# KITTITAS COUNTY

## DEPARTMENT OF PUBLIC WORKS

TO: All Staff  
FROM: Public Works Plan Review Team  
DATE: February 8, 2022  
SUBJECT: BL-22-00001 Colazo

The Public Works Department has reviewed the Request for Boundary Line Adjustment Application.

BLA EXHIBIT
SECS. 23 & 26, T. 19 N., R. 17 E., W.M.

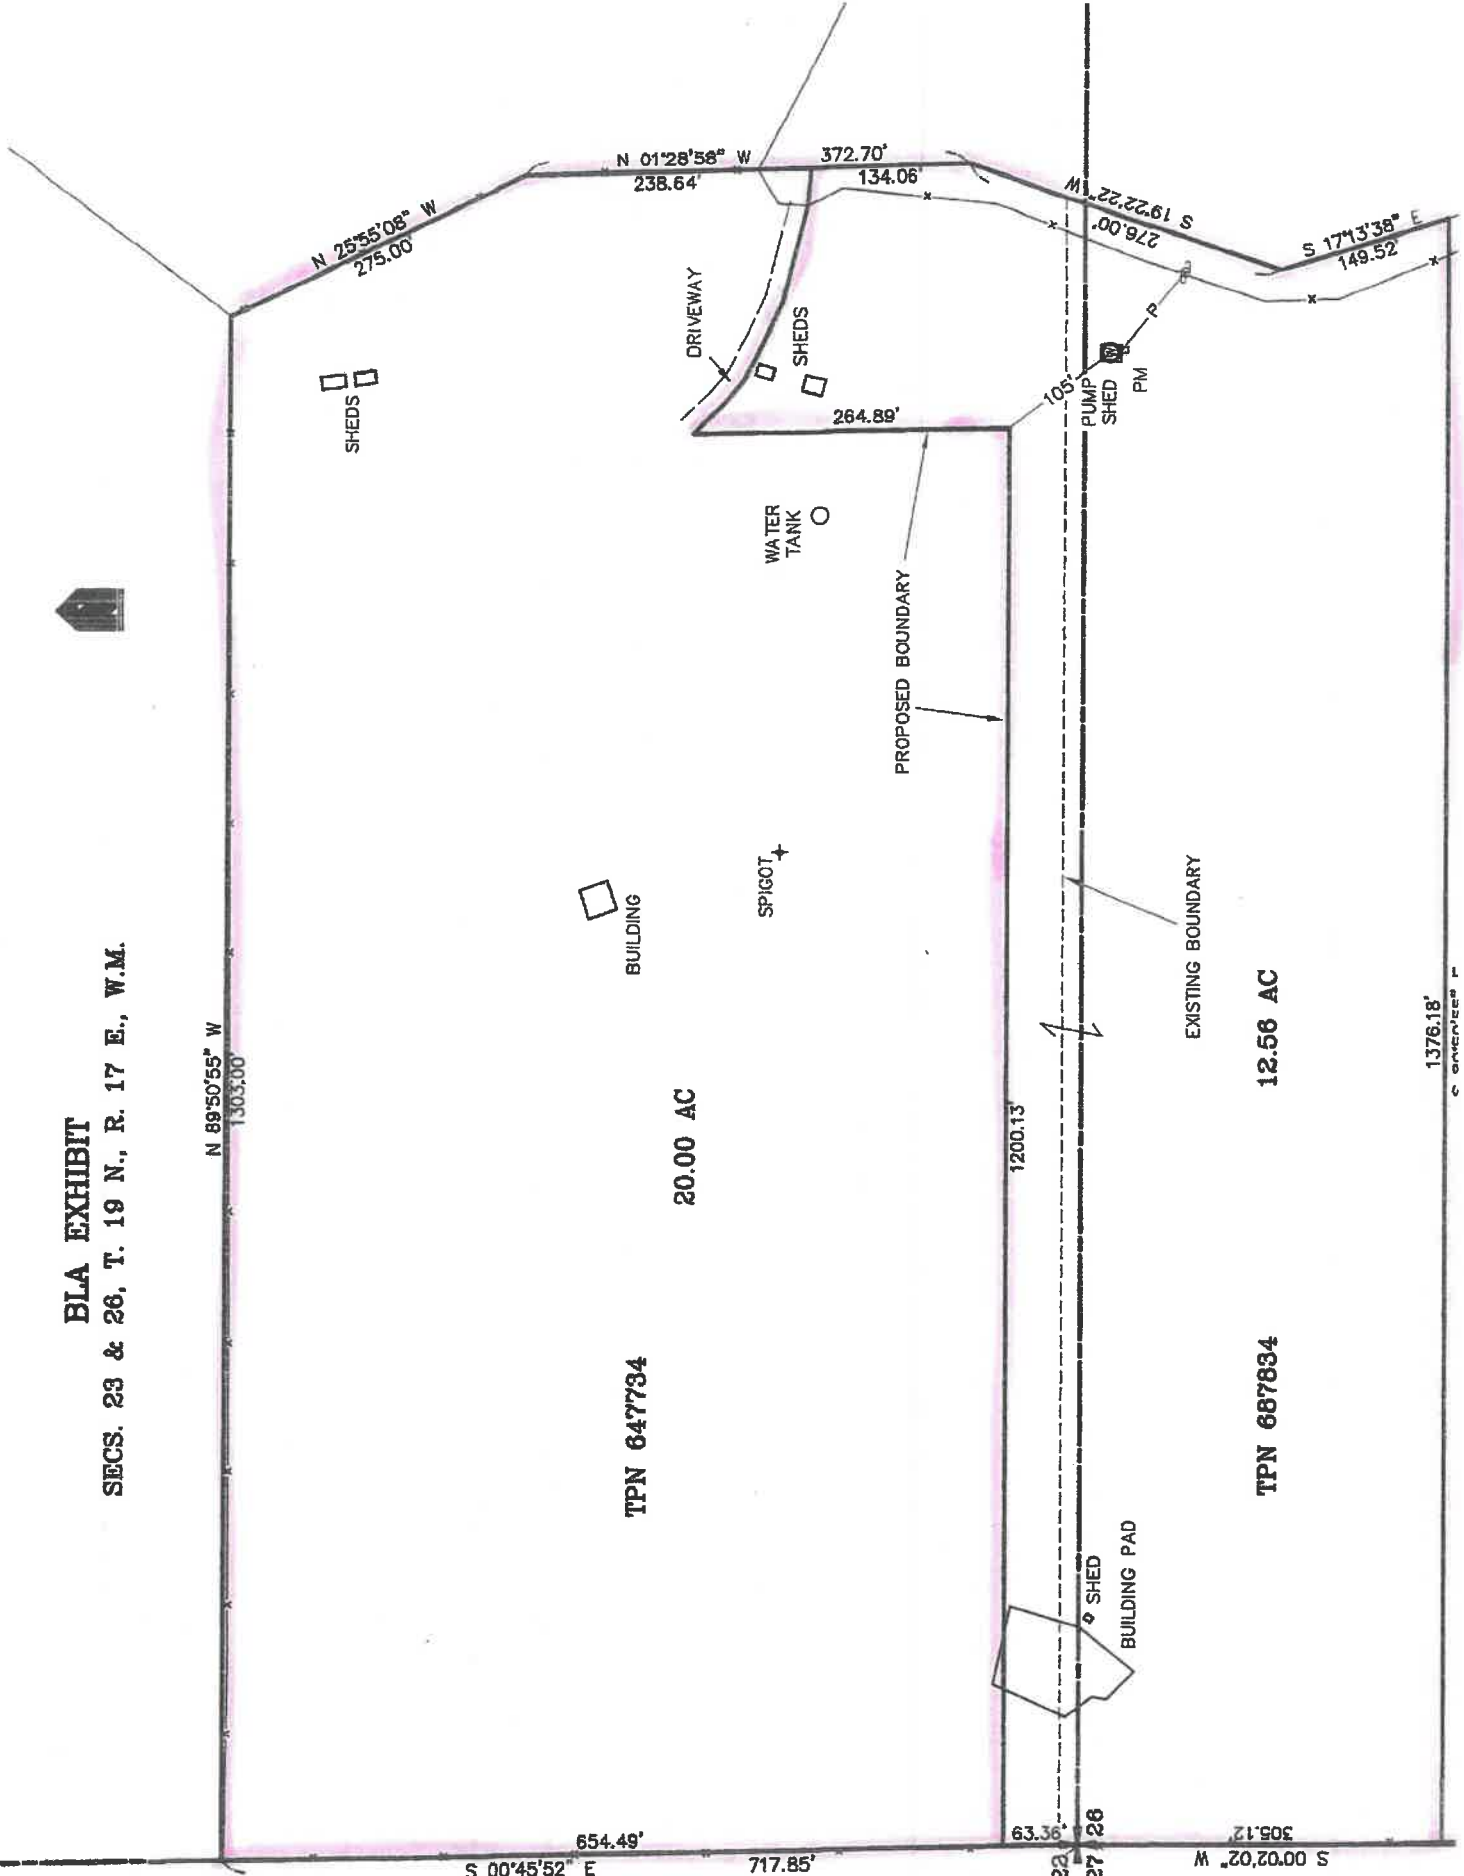
- a. Please be aware that Public Works does not have a private road certification on file for Ellensburg Ranches Road. The accesses to the parcels involved will be required to meet current Kittitas County Code Road and Bridge Standards when a building permit is applied for. A road certification permit will be required from Public Works to bring Ellensburg Ranches Road to the current private road standard.

- g. In addition to the above-mentioned conditions, all applicable Kittitas County Road Standards apply to this proposal.
- h. As the provided plat is more of a site plan than a record of survey, any comments regarding survey will be reserved for final.
